Re: 58 Elm Park, Ferring

Further to the application which was recently submitted for loft extension/conversion and rear extension at the above I am writing to advise that there have been a couple of changes to the scheme which are summarised as follows:

ground floor

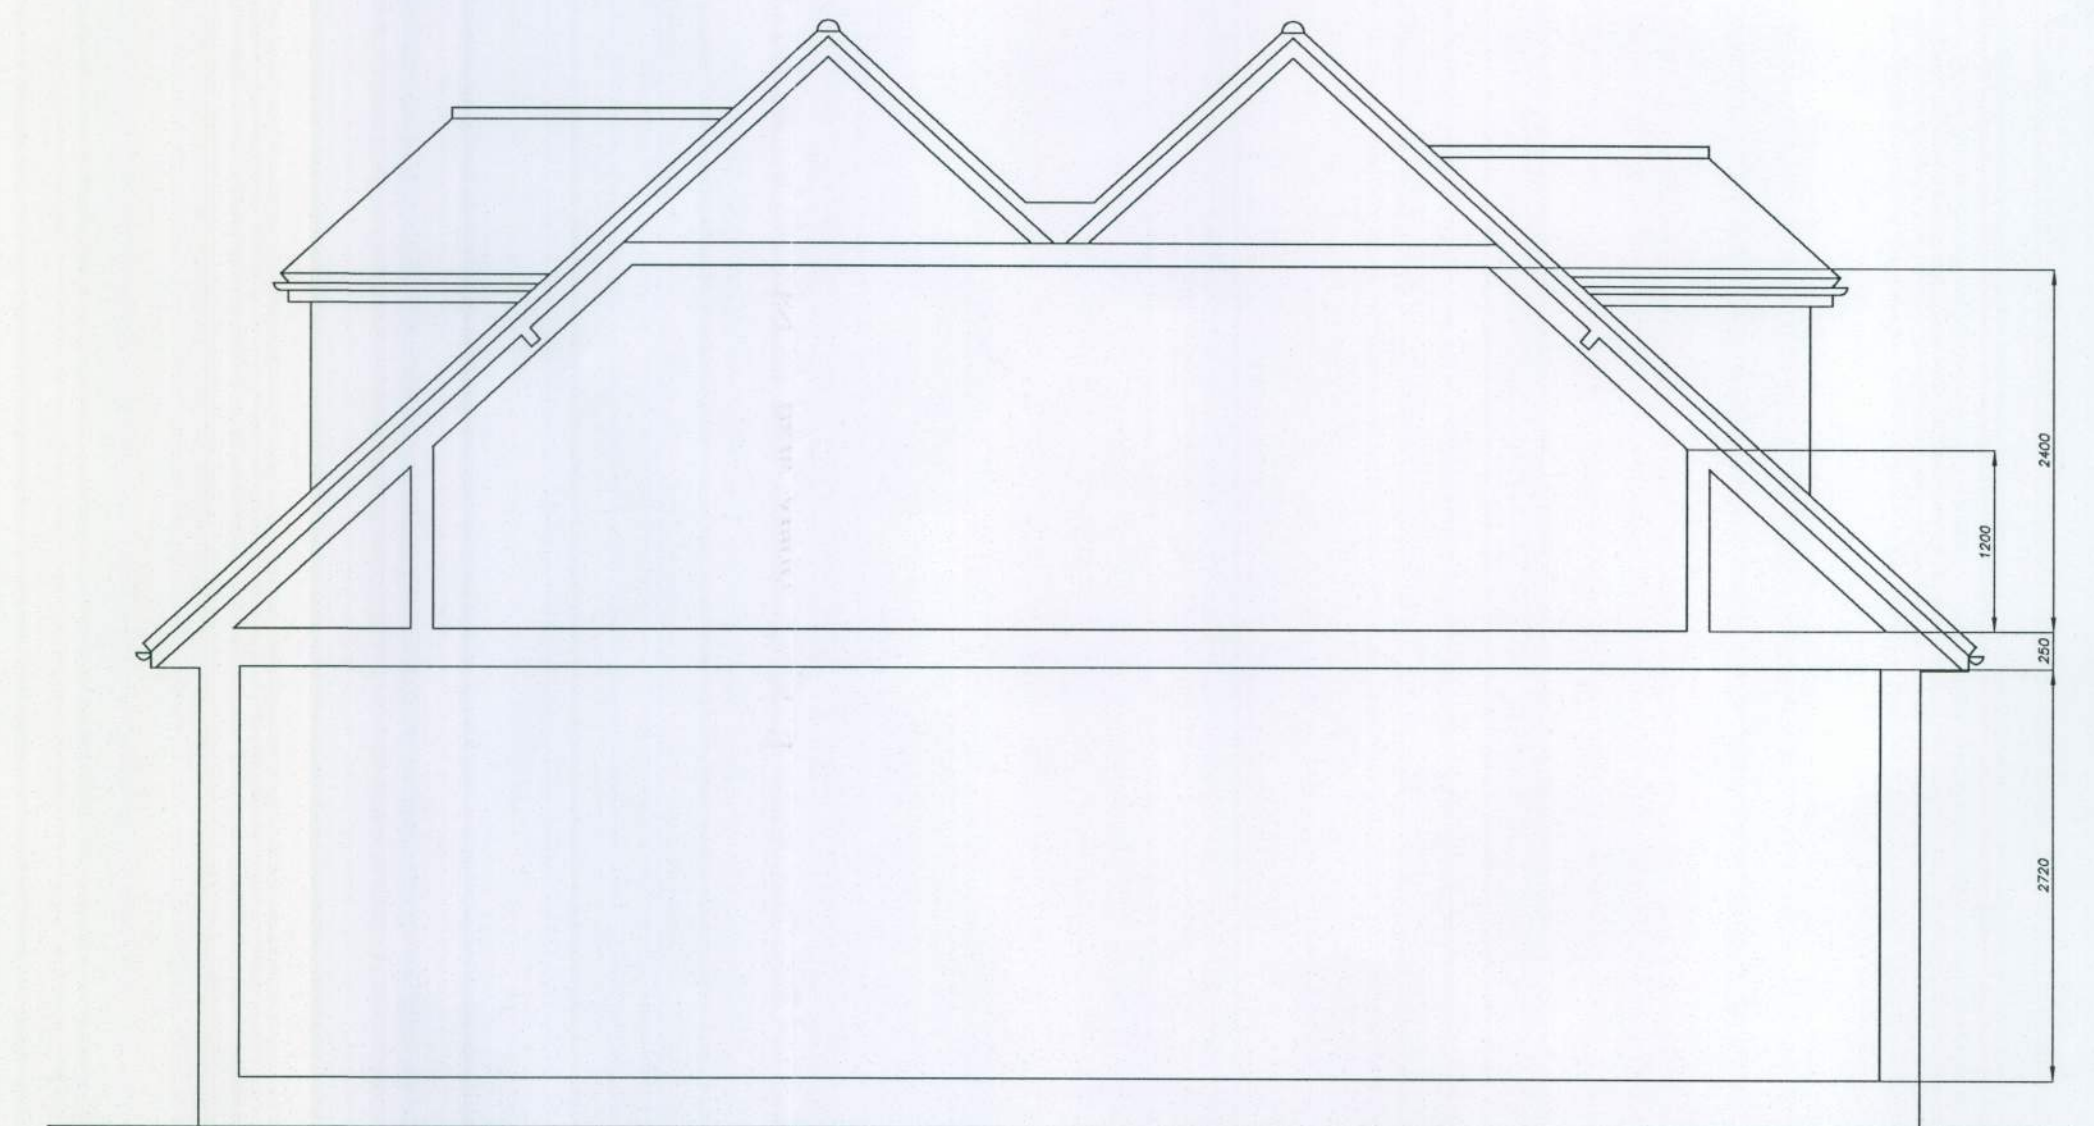
1. The rear dormer has been increased in width from a double casement window to a triple casement window.
2. The north and south gables are now both shown clad with weatherboard.
3. The western bedroom wall has been moved to the east to increase the size of the bedroom.
